Kariong Sand and Soil Supplies (SSD 8660)
Summary of Response to Submissions – March 2021

PROJECT: PROPOSED KARIONG SAND & SOIL SUPPLIES FACILITY - SSD8660
GENERAL ARRANGEMENT PLAN

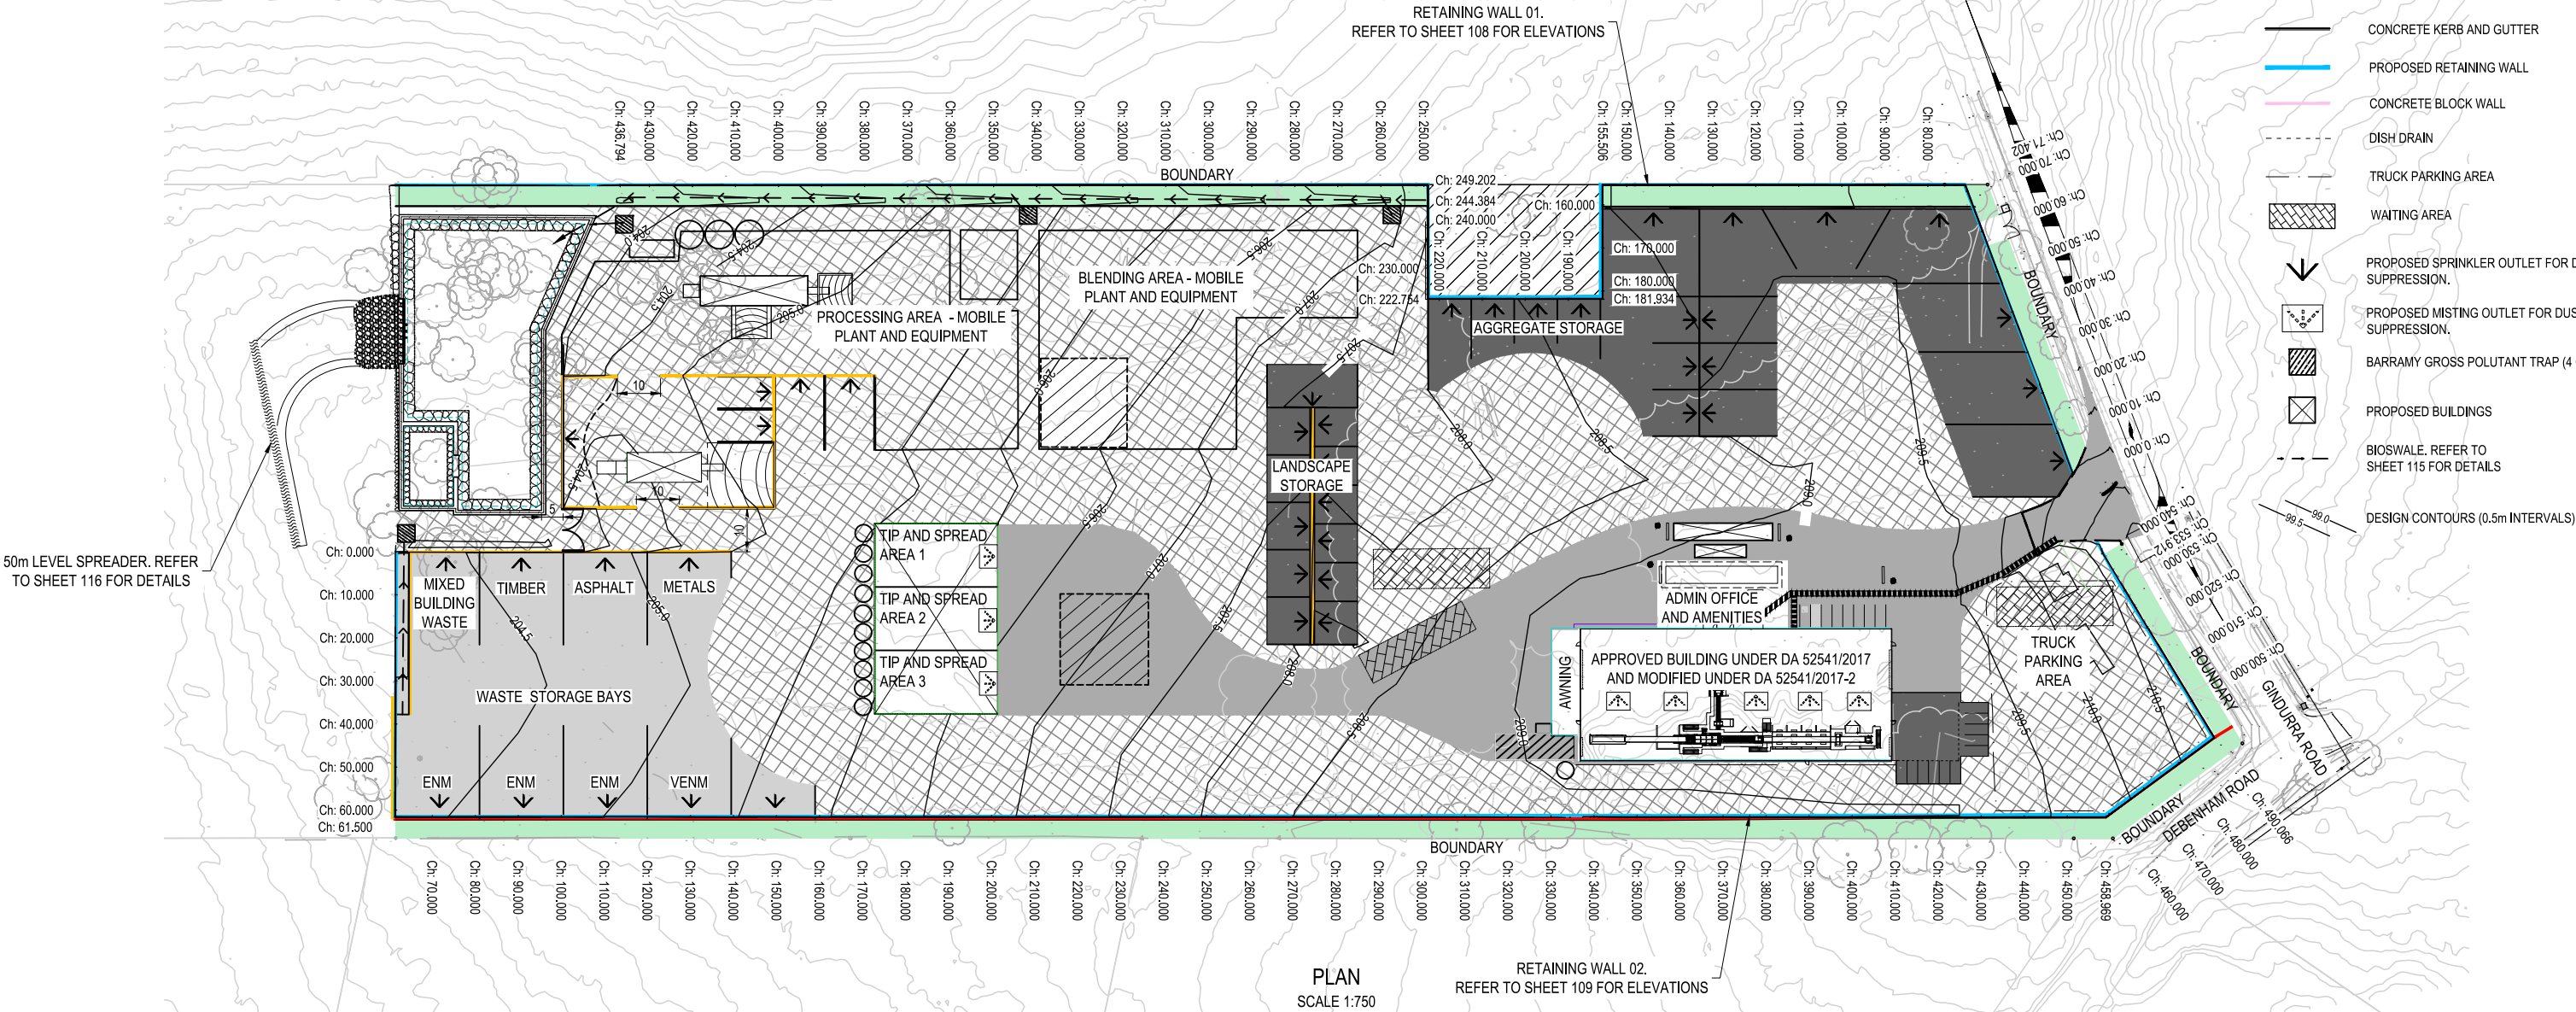
11	Traffic	Central Coast	The entrance design must not obstruct the footway area along Gindurra Rd. The proposed concrete median strip, which would require truck leaving the facility to only turn left, must not encroach on the footway area.	Noted and agreed. It is proposed that there is a gap in the median strip to allow pedestrian thoroughway.	Refer to letter from SECA Solutions at Attachment 4.
12	Biodiversity	DPIE	The Department notes the development proposes to construct sewers along the eastern boundary of the southern half of the site to connect to Council's sewage main on Kangoo Road. Please clarify whether construction of the sewers requires clearing of the existing bushland which is proposed to be retained and whether this has been addressed in the Biodiversity Assessment Report. Please clarify the total area to be removed, any biodiversity impacts caused by the vegetation removal, and resulting biodiversity impact offset requirements.	The sewer connection was approved as part of an earlier development application for the site (DA 52541/2017), in consultation with Central Coast Council. The sewer line has been installed. No further clearing will be undertaken.	N/A

Figure 5. Crusher and Mulcher Fully Enclosed Shed Design

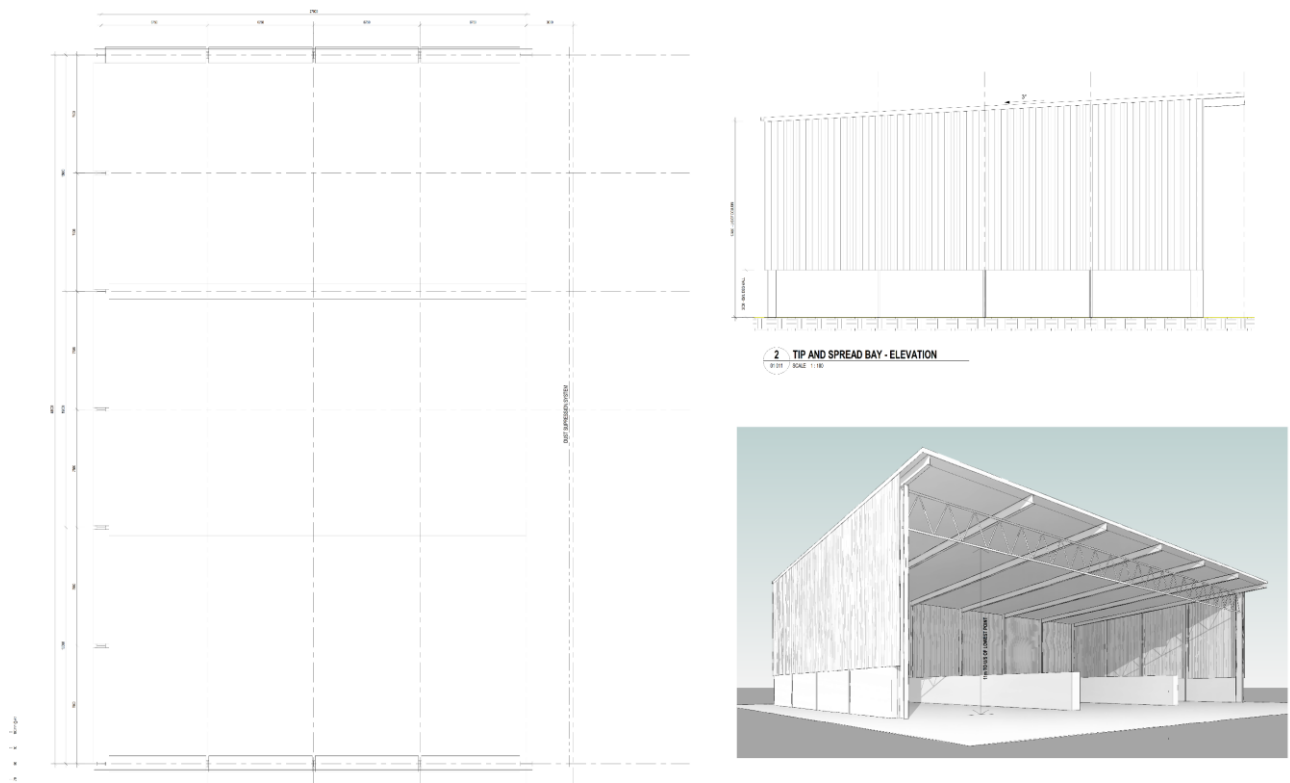
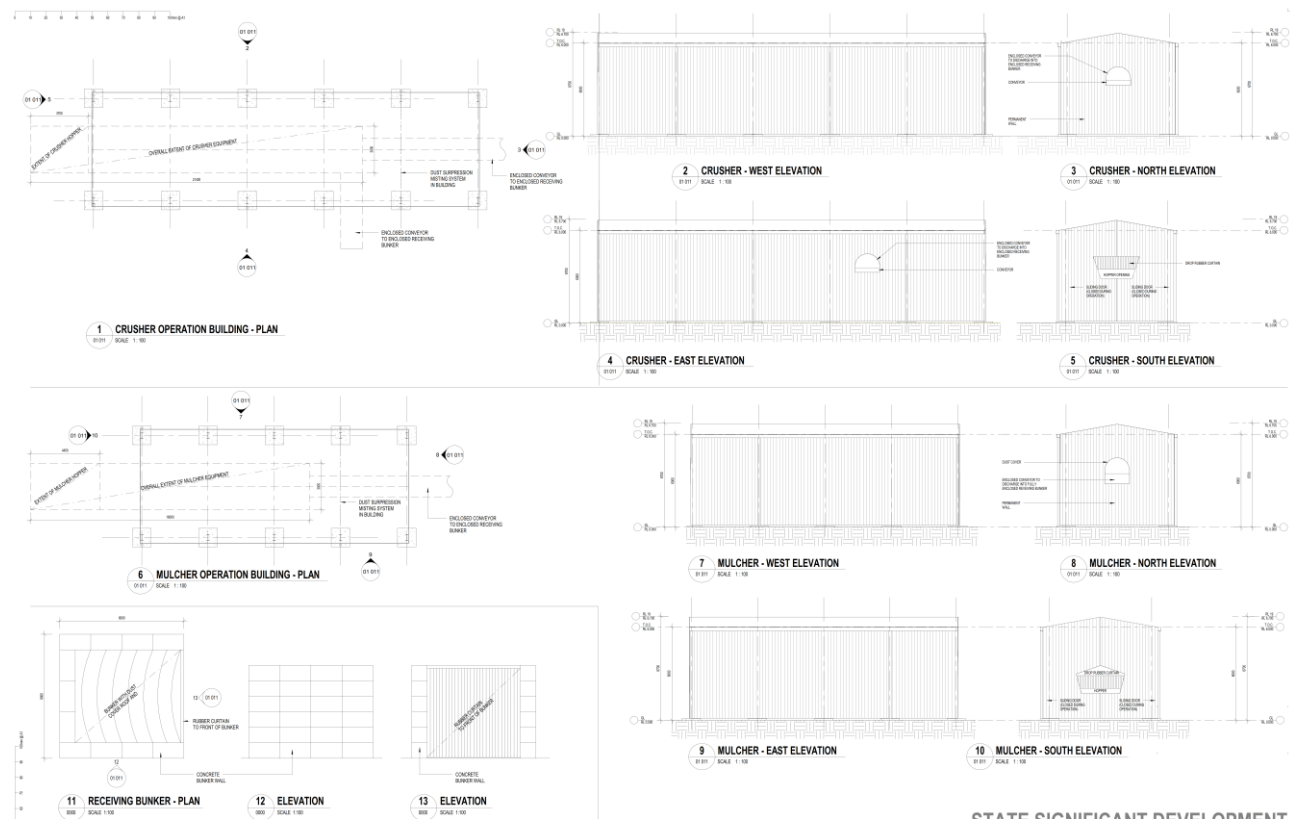
No.	Issue	Agency	Comment	Summary response	Where a detailed response is provided
3	Water	EPA	The RtS includes changes to some of the building enclosures. In some sections of the RtS, the roof material of the crusher and mulcher buildings is Colourbond steel, elsewhere it is stated to be canvas. It is recommended that the applicant commits to roofing material that will be impervious to water to minimise the generation of polluted runoff.	Agreed. The roof material for the crusher and mulcher buildings will be sheet metal, per original plans. Waterproof canvas coverings will be used to enclose the bunker containing the stockpiles of processed materials after they have left the processing buildings. The waterproof flexible coverings proposed are widely used to enclose stockpiles and processing operations in the waste and recycling industry.	Appendix 3 of Supplementary Response to Submissions Report.
